14 December 2018

Reference: F6 Extension Stage 1 – SSI 8931

Thank you for the opportunity to review and comment on the Environmental Impact Statement for the proposed F6 Extension Stage 1 Project. The following are our comments.

Figure 6-2
Sheet 2 of 4

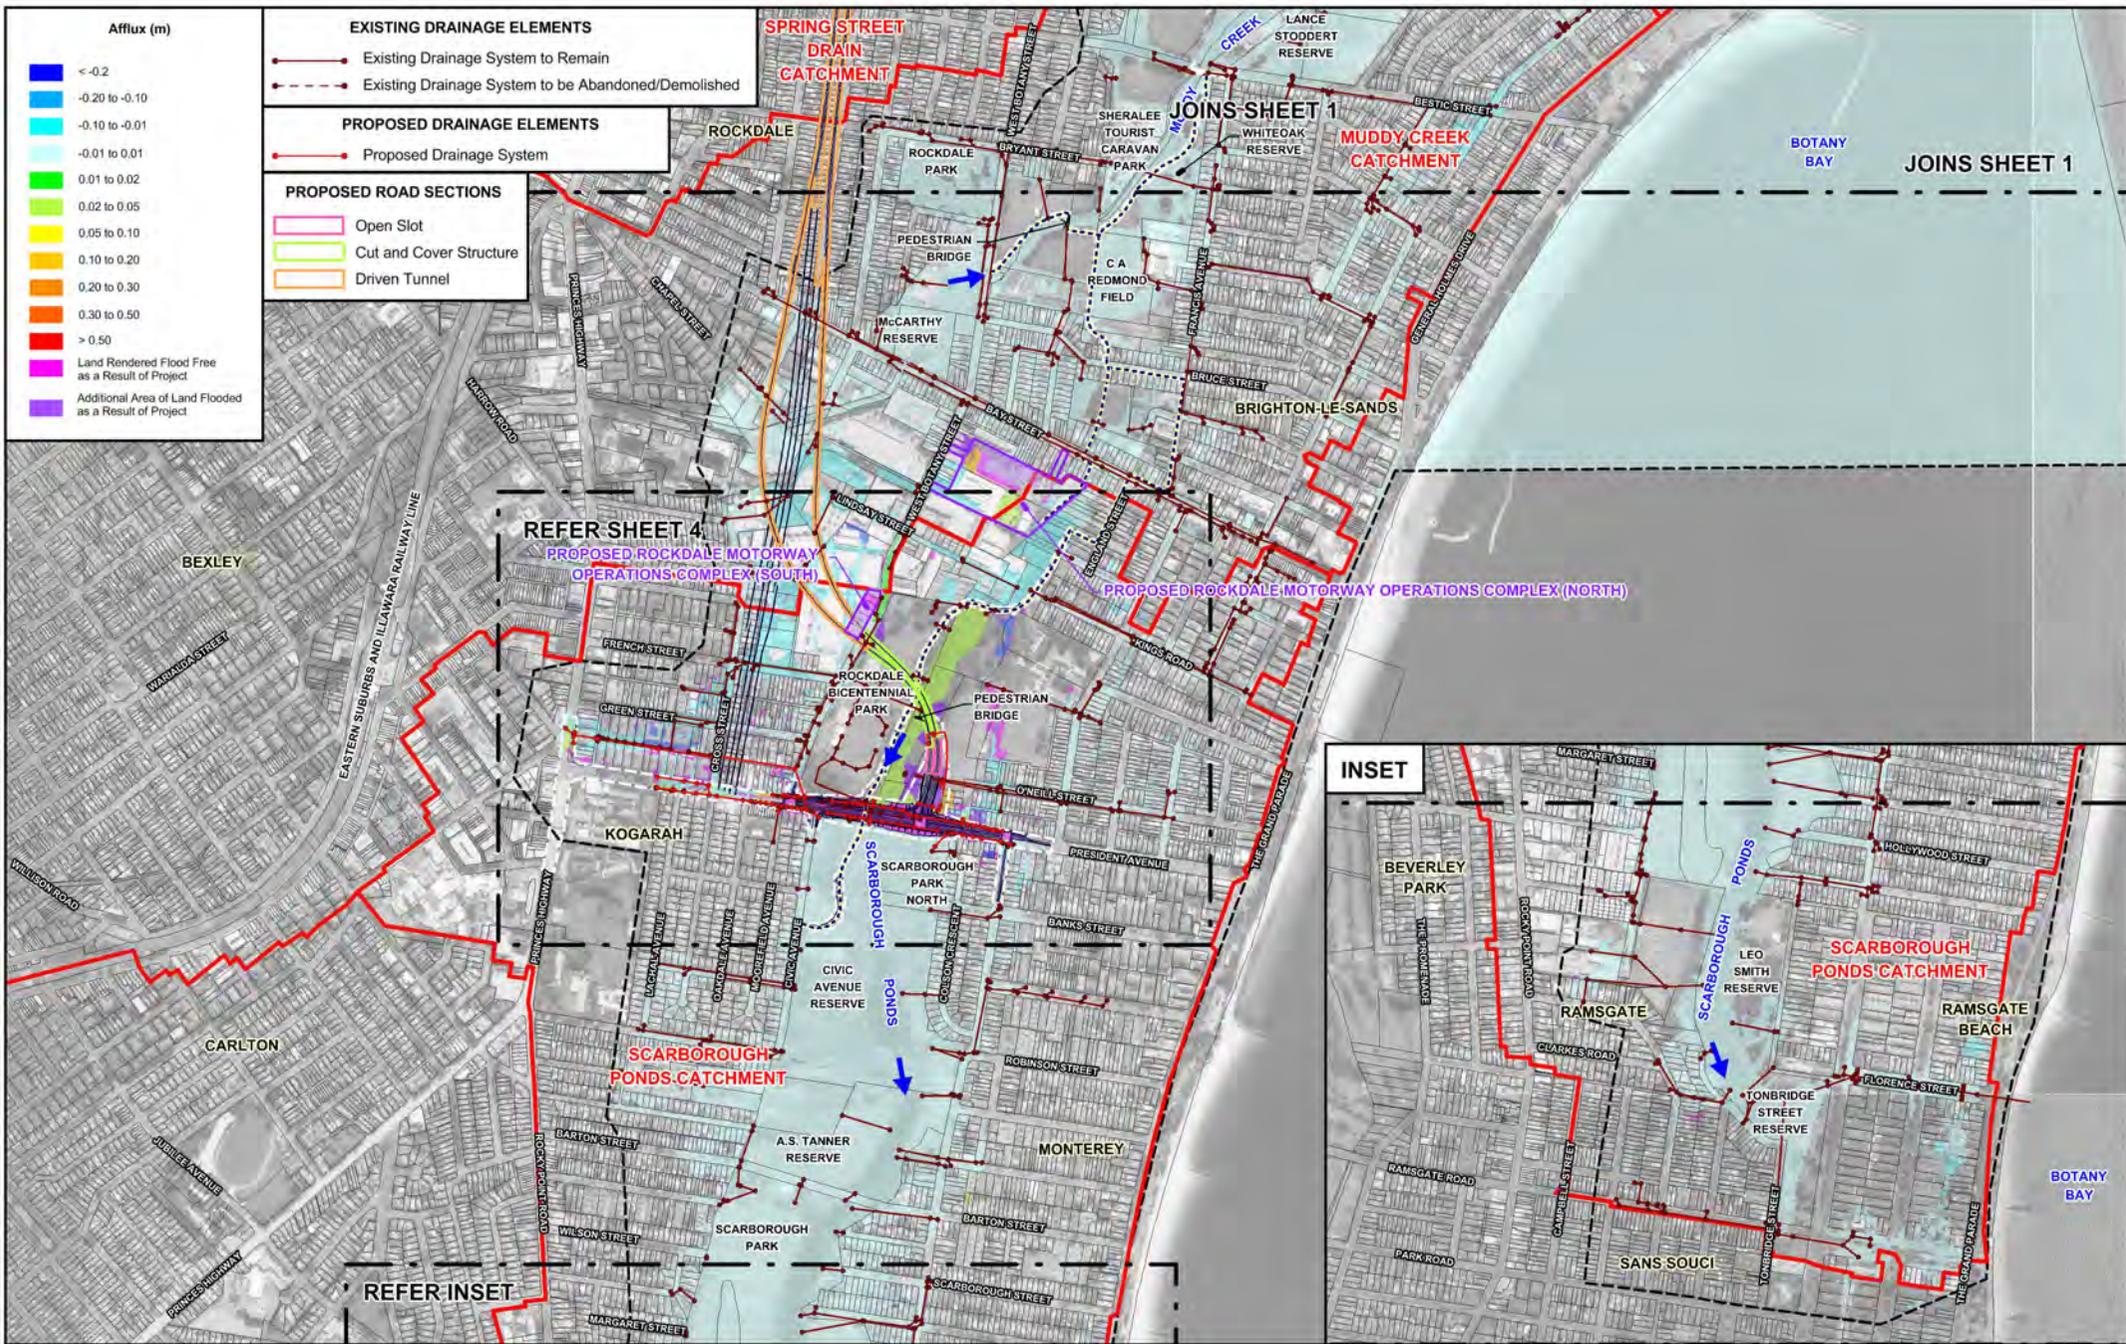
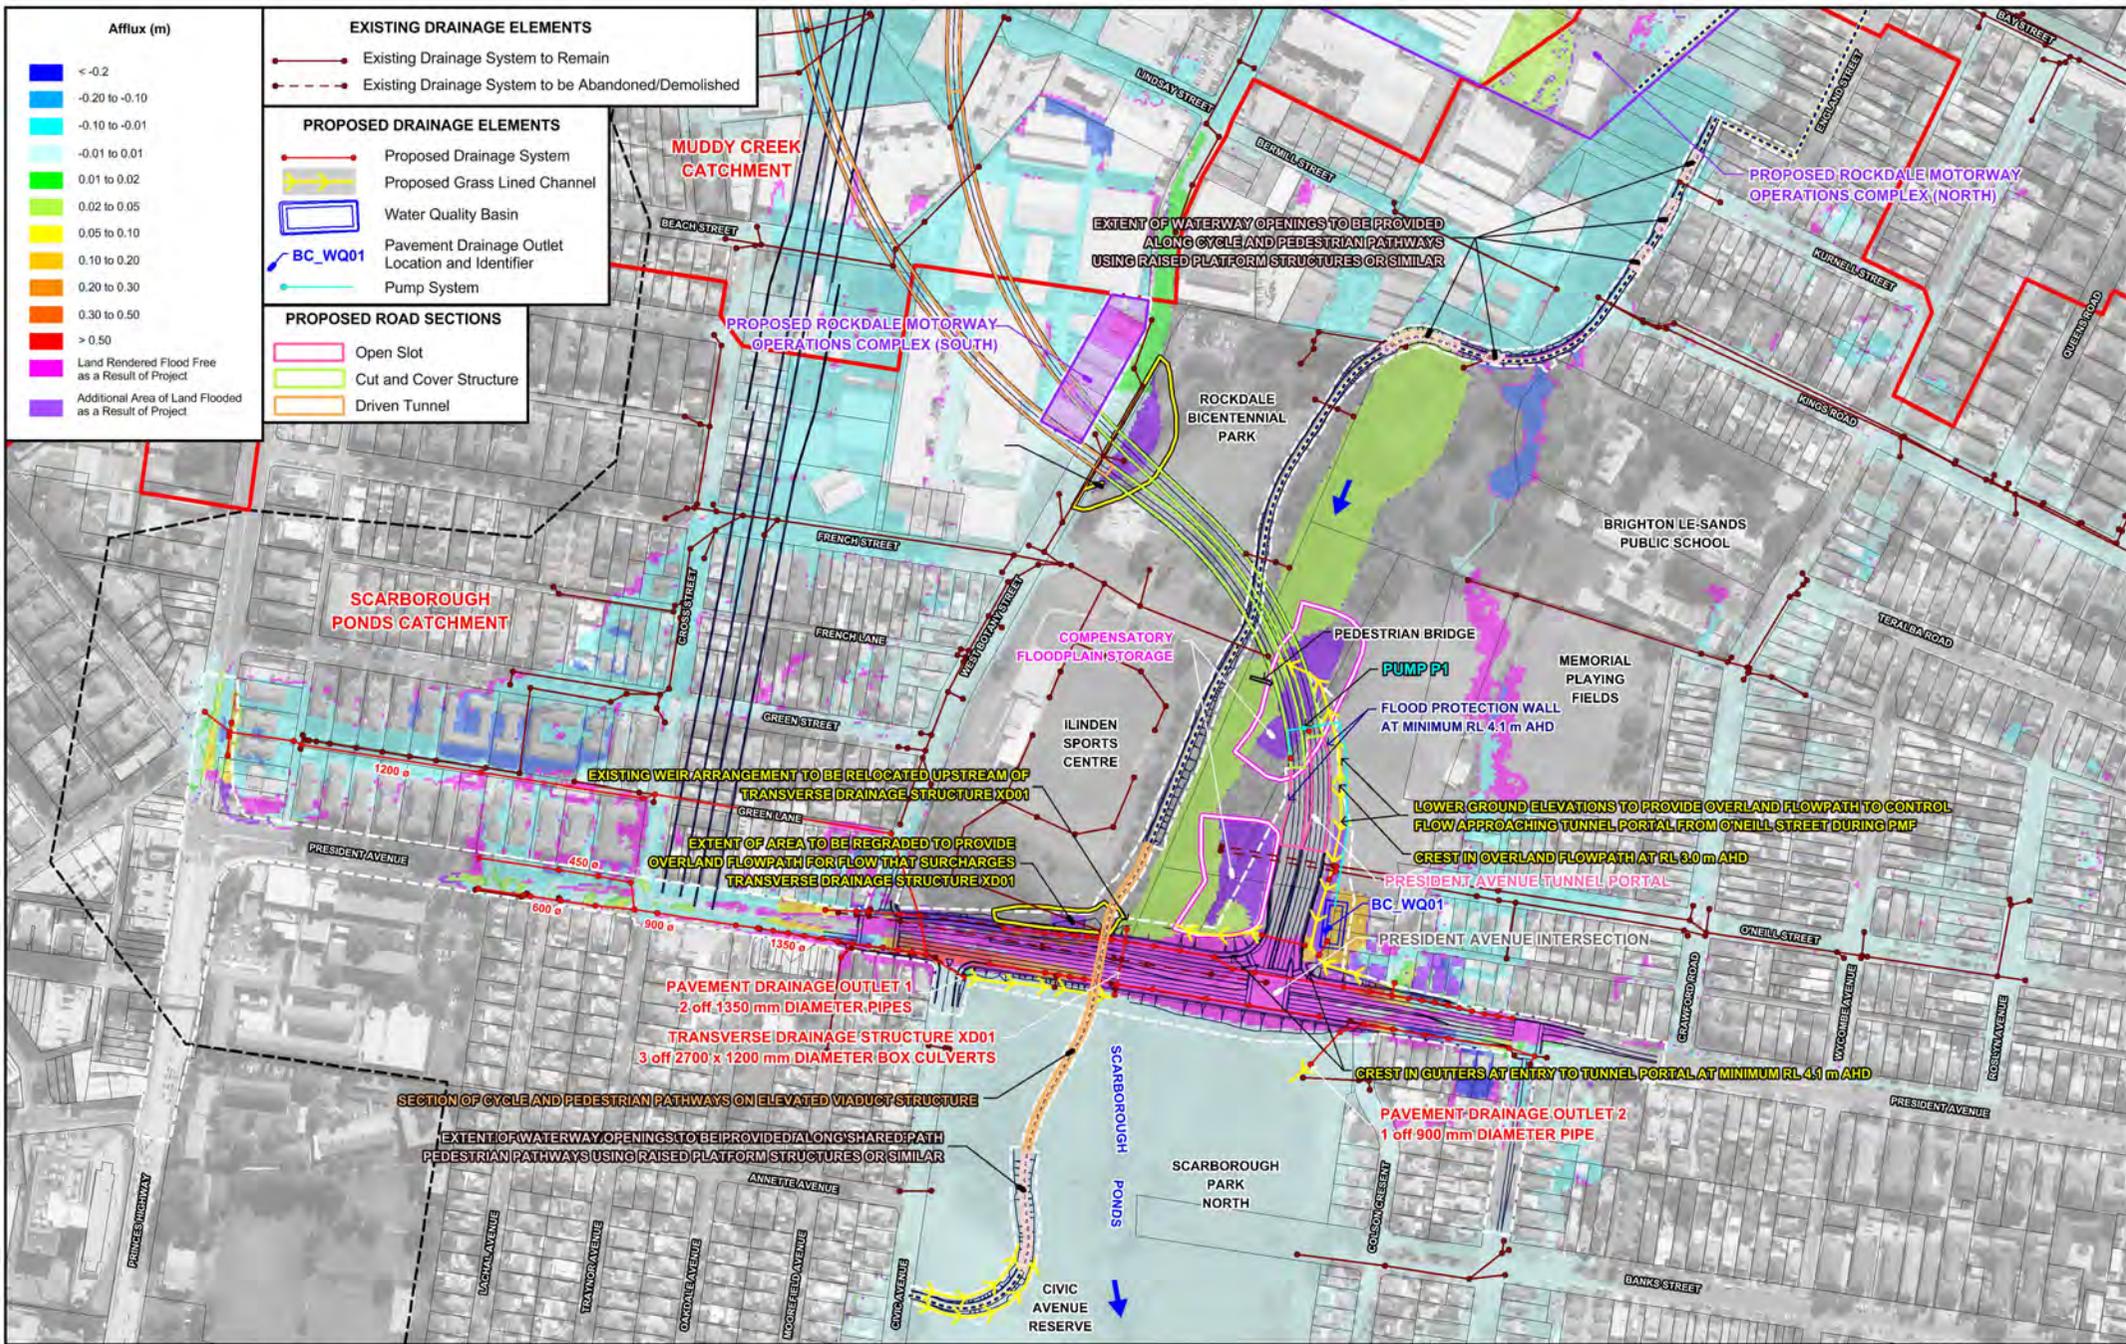
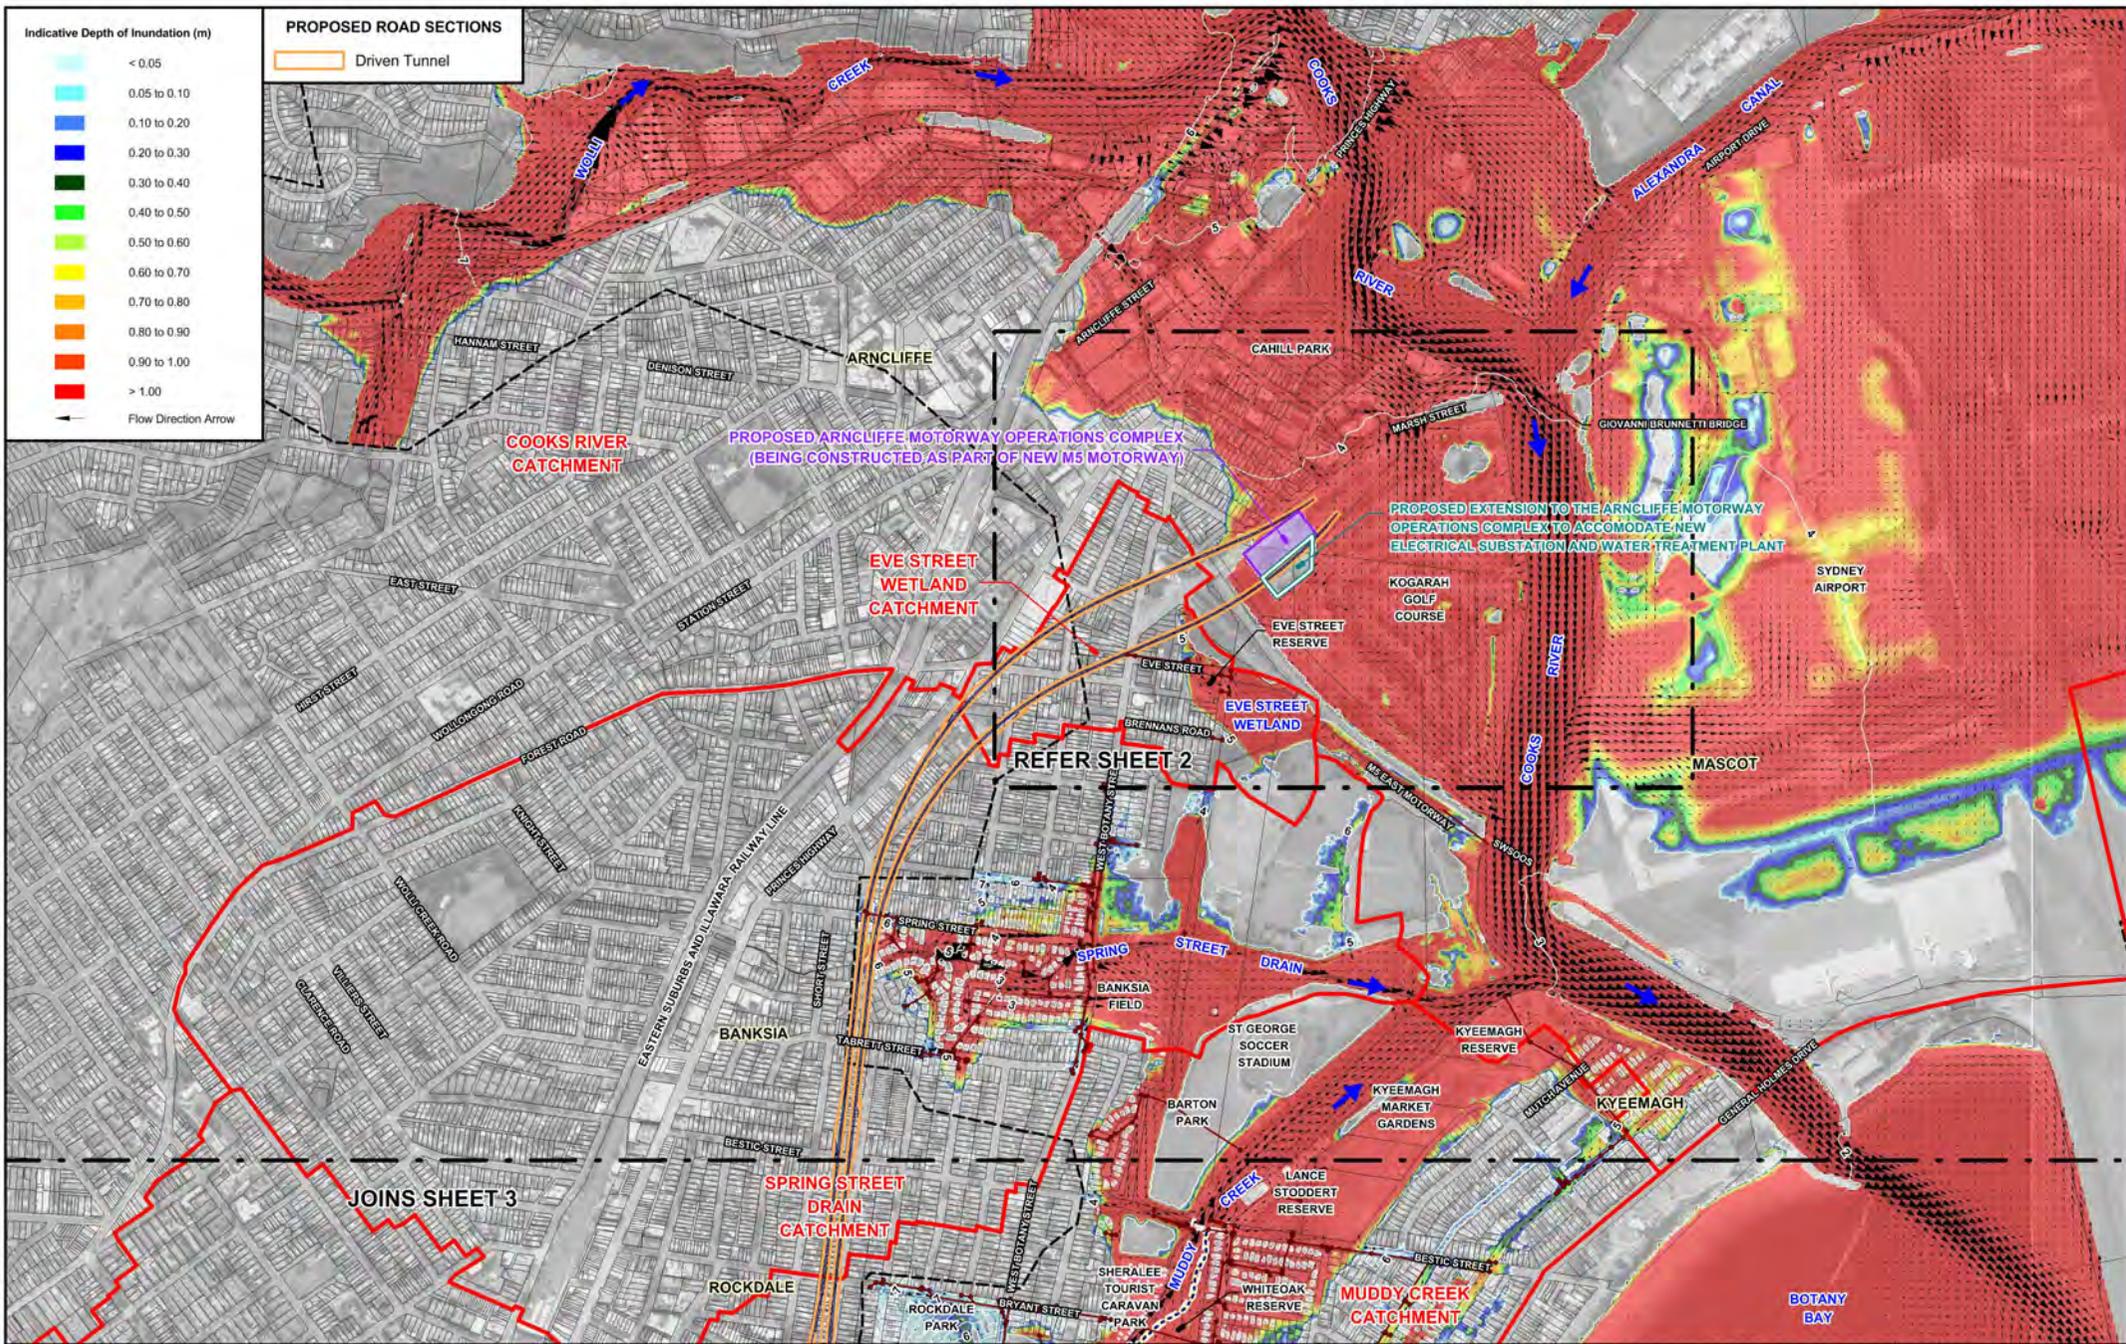
- The proponent should review the proposed 1% ARI flood immunity standard for surface road pavements.
 - Surrounding roads do not have this level of service and a high standard for isolated sections of road would not be supported where there is potential impact to flood sensitive nearby properties.

- This is particularly the case where local road pavements are proposed to be raised / perched and serve to obstruct cross flows (by capacity limits or blockage incidents) to the detriment of nearby properties.

- While the project is not deemed sensitive to climate change impacts, the project impacts to local properties in combination with climate change should also be evaluated within a prudent selection of climate change and blockage incident scenarios.
